Marine
Management
Organisation

Planning Inspectorate Reference: EN010098
MMO Reference: DCO/2018/00014
Identification Number: 20029896

Planning Act 2008 - Application by Ørsted Hornsea Project Four (UK) Limited (“Ltd”) for an Order Granting Development Consent for Hornsea Project Four Offshore Wind Farm

Deadline 4 Submission

Figure 3: 1979 and 2011 bathymetries of Smithic Bank (top and middle) and a comparison of the 1979 and 2011 bathymetries (bottom).

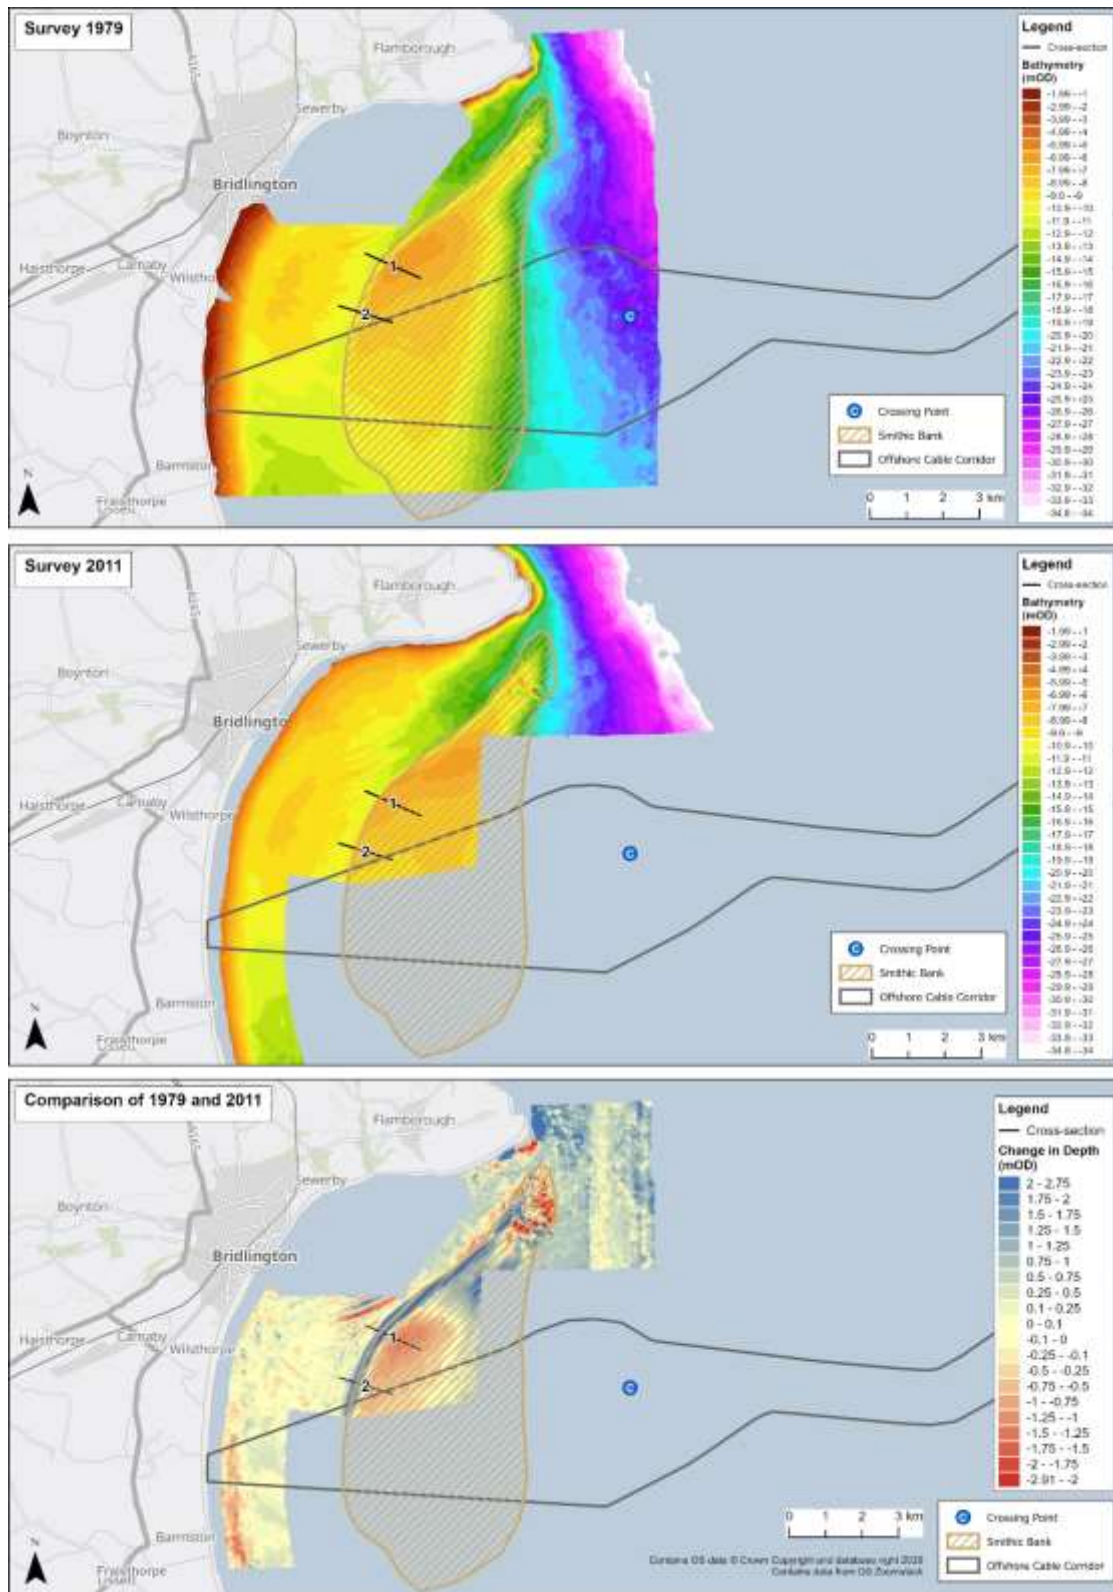
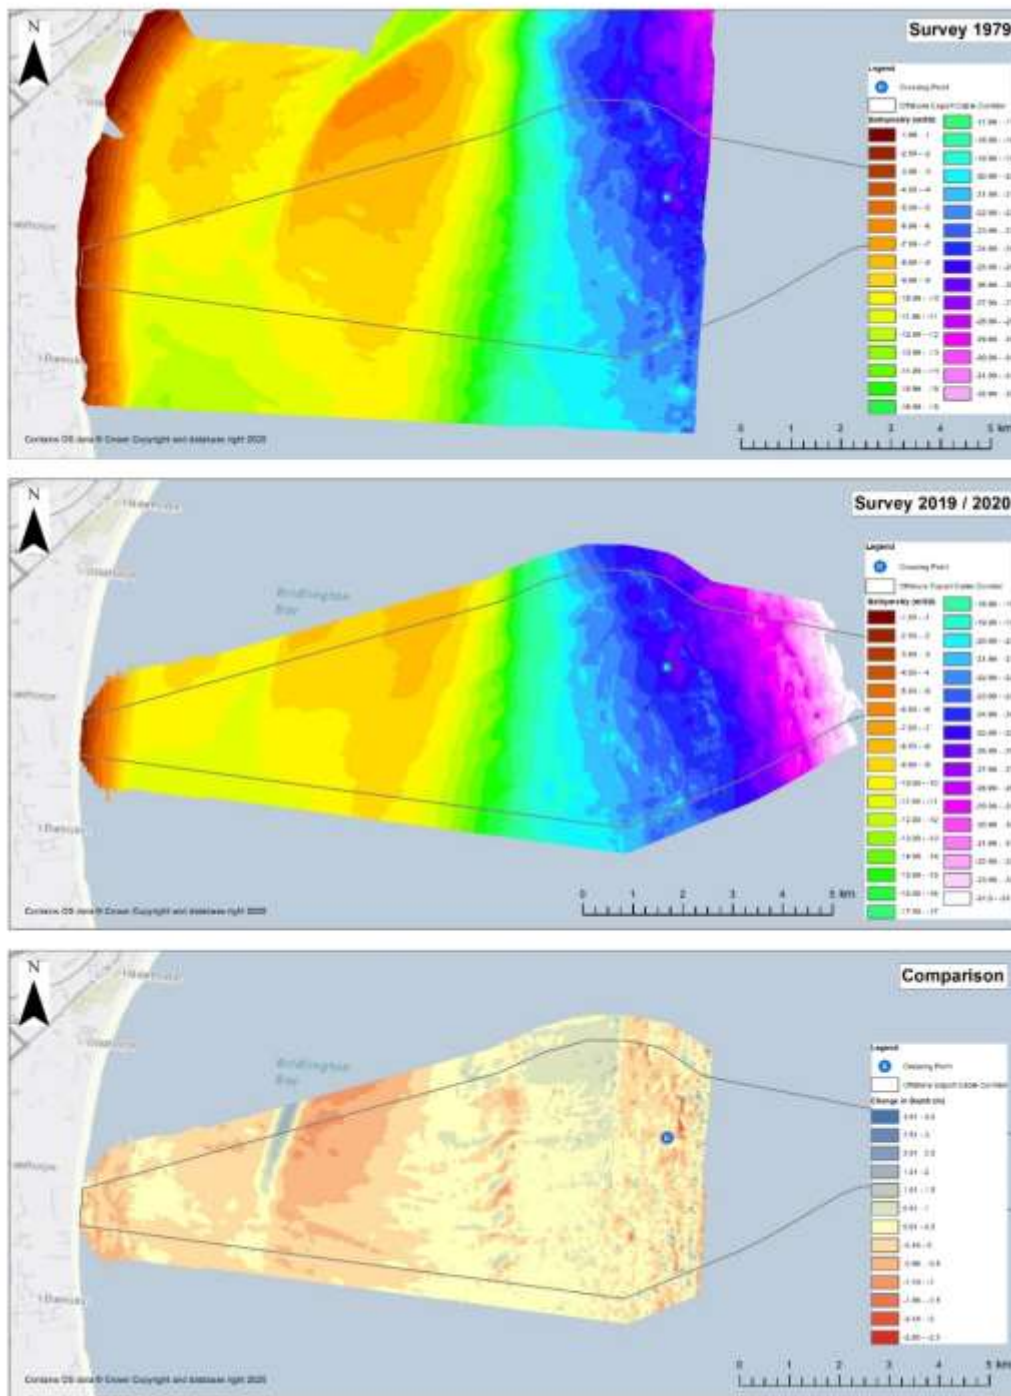
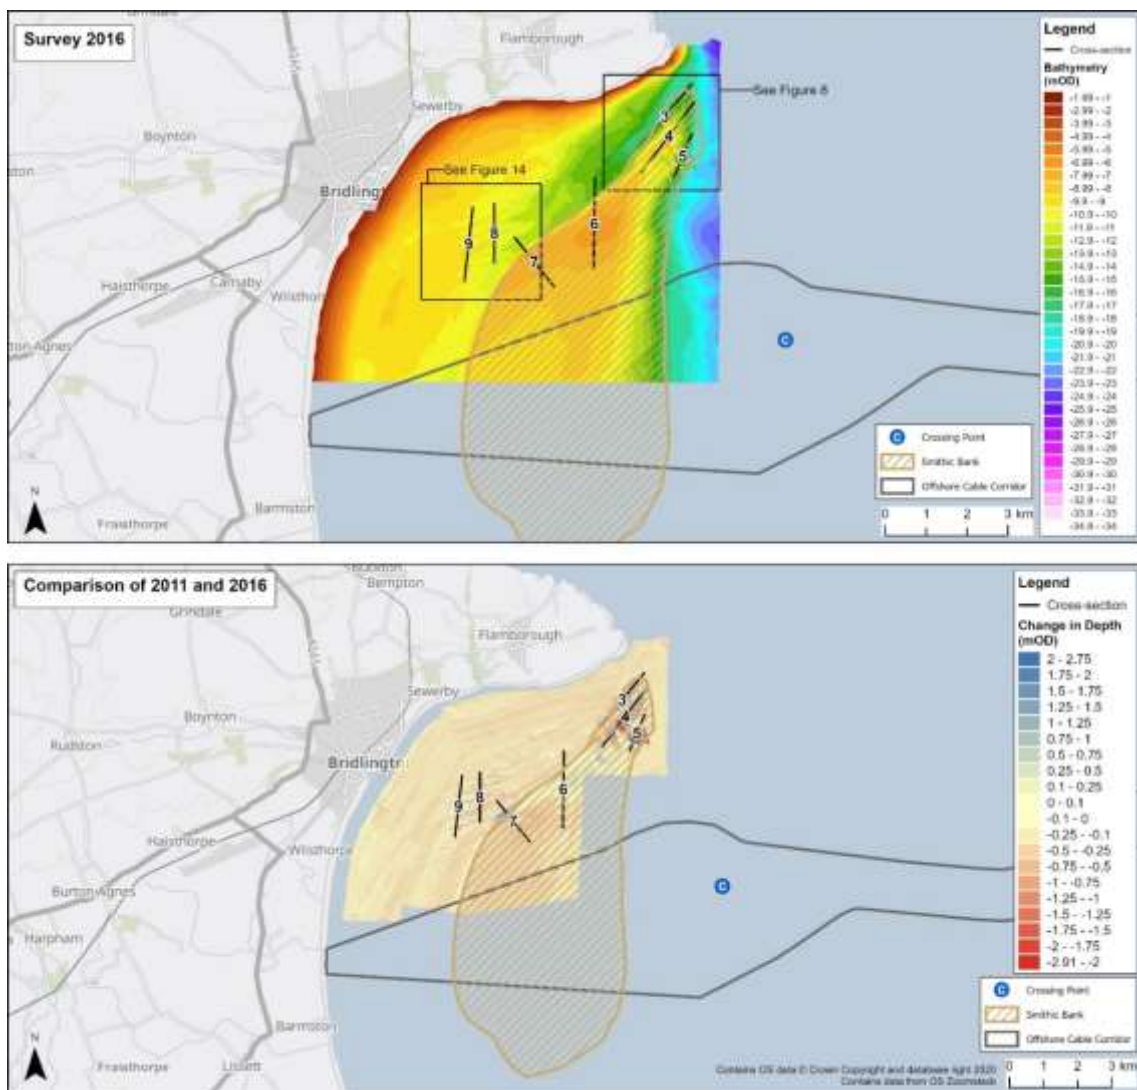
3.2.3. Whilst the MMO support the use of Expert Geomorphological Assessment (EGA) to assess the potential impacts on Smithic Bank, we understand there are no Guidance/Best Practice documents for this. EGA varies in quality depending on the detailed scope of work (which has not yet been not supplied), the time available and the expert group assembled. As this stage, the quality and outcomes can't be assessed.

Figure 22: Location of Flamborough Front according to North Sea Task Force (1993). Flamborough Front is outlined in red box and is approximately linear and located at just south of 54°N.

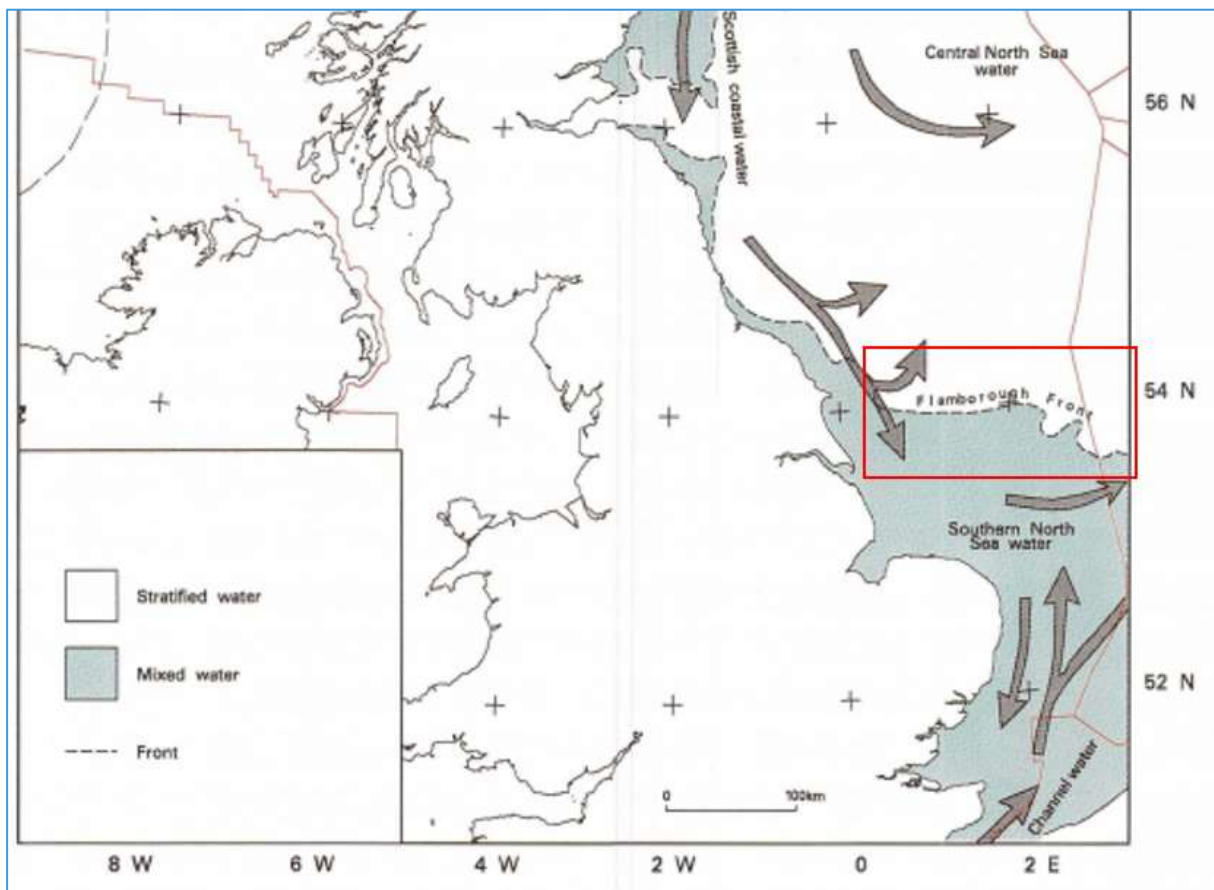
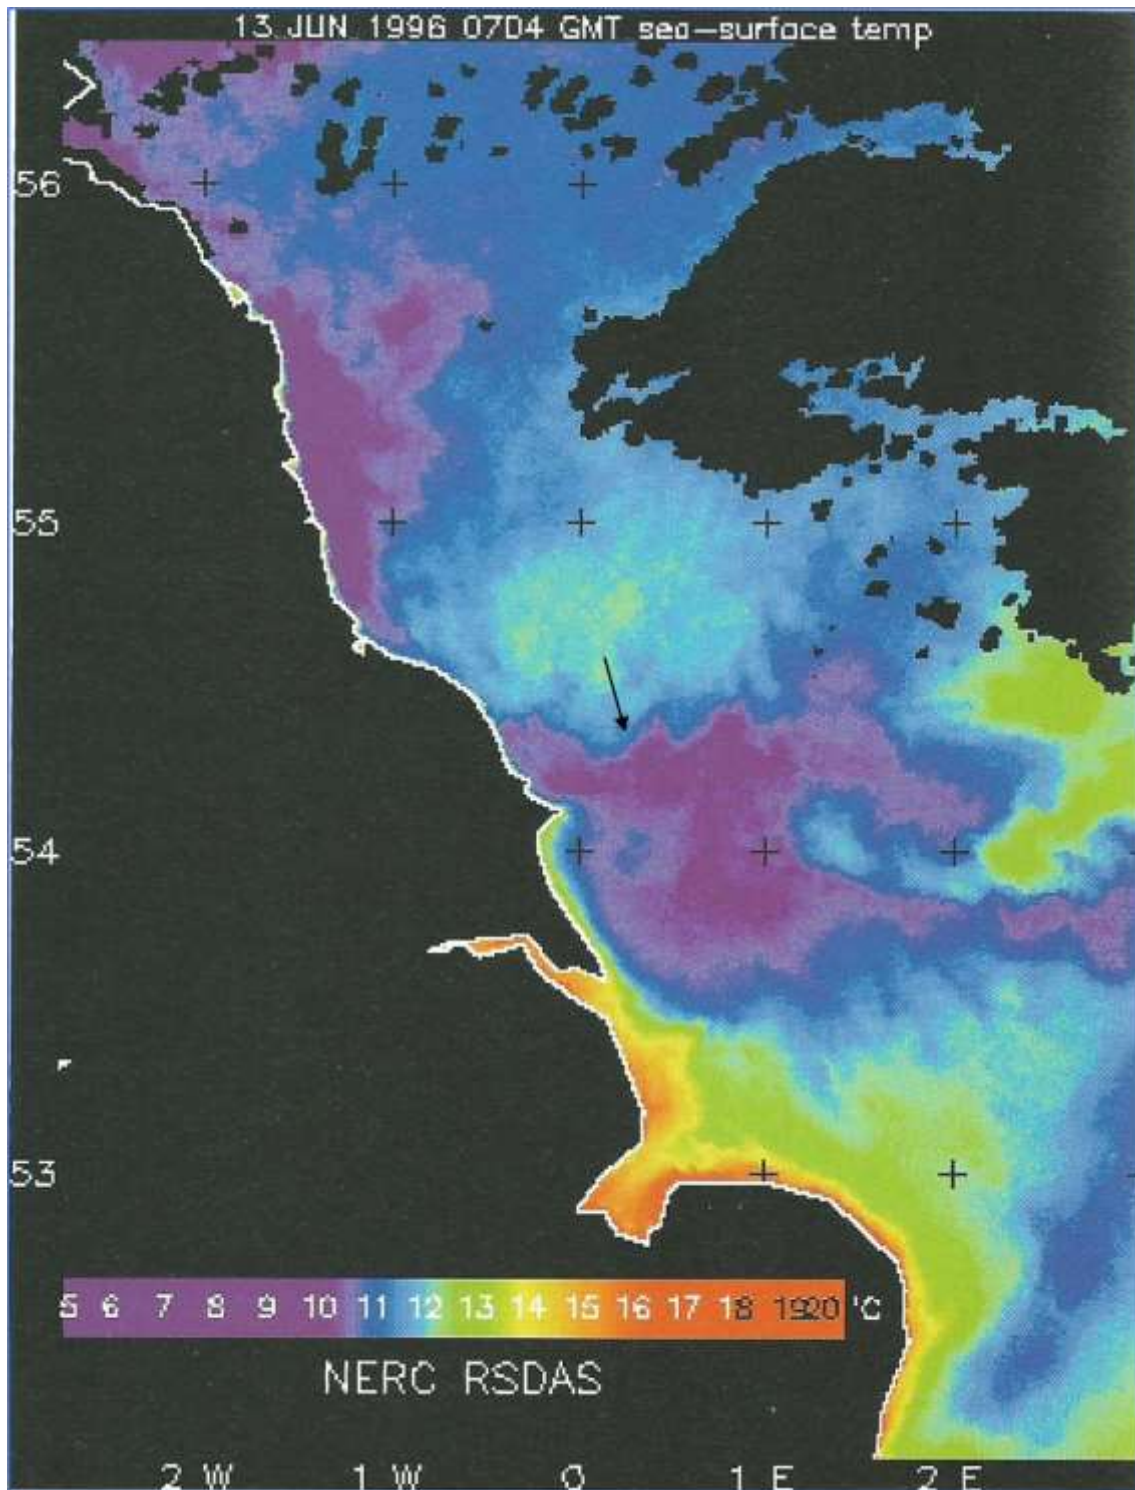
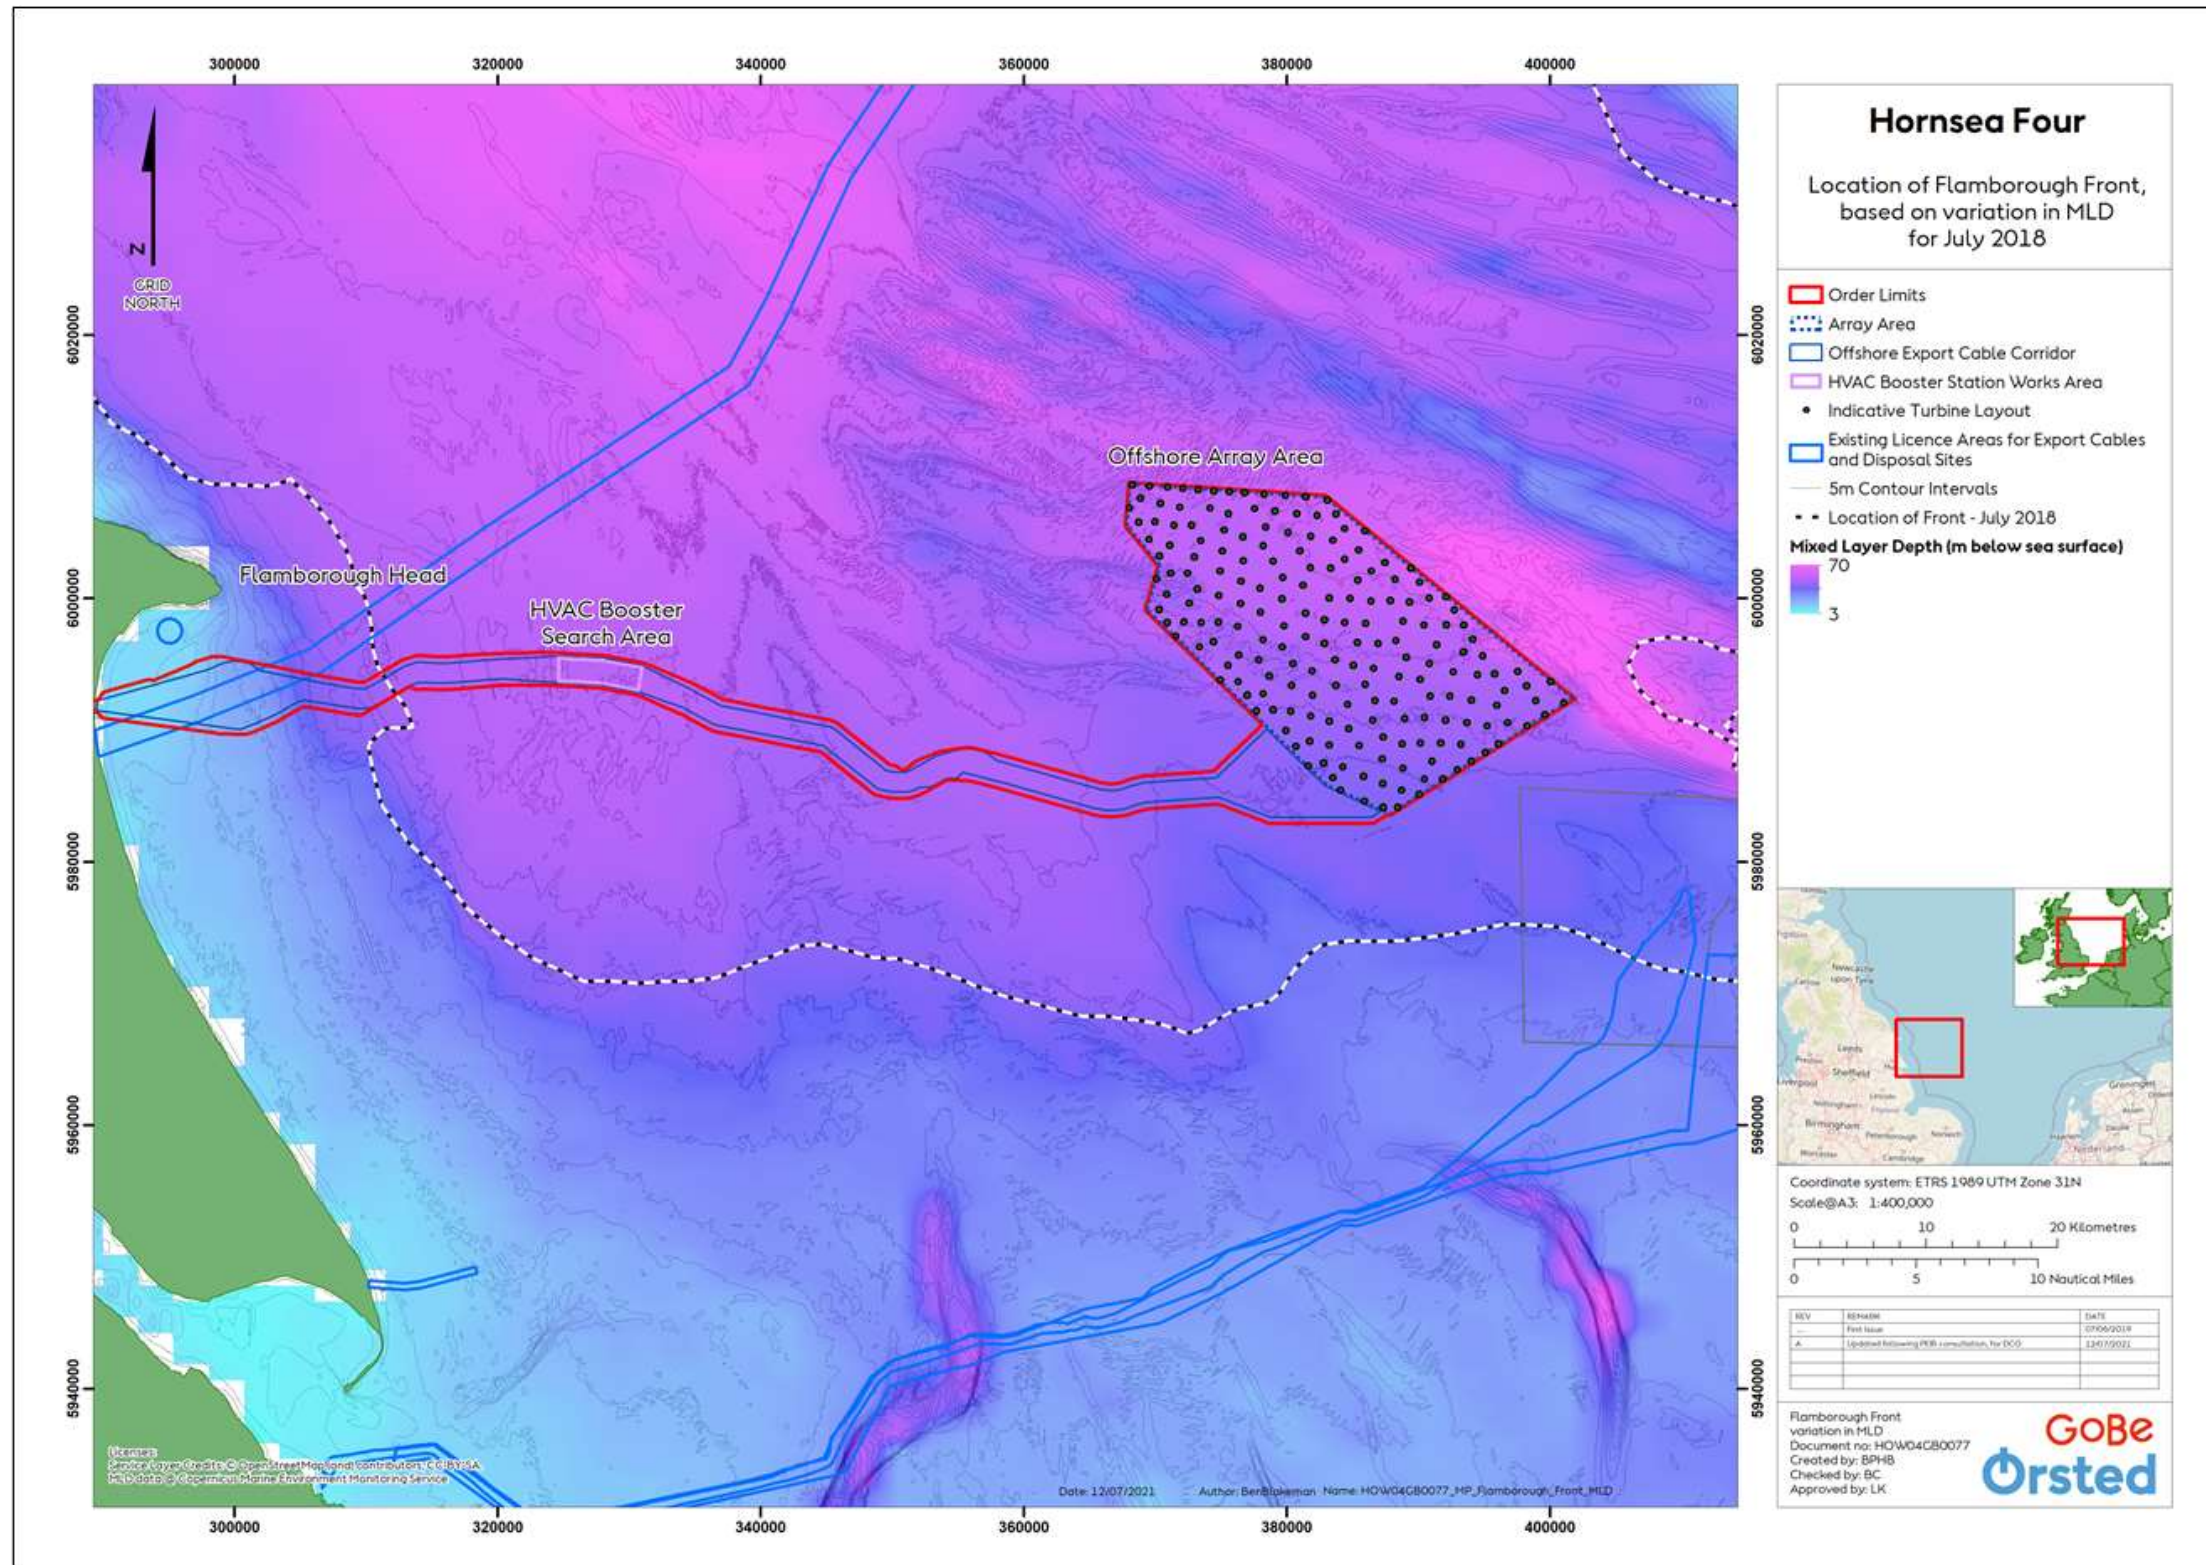
3.2.4. Regarding the Flamborough front, it is surprising to see that Historic Trends Analysis is not available, as historic satellite images are available in various archives, for example in ESA Sentinel 3 imagery for Infra-red parameters (section 2.1.1.1), we advise that this will be a useful resource.
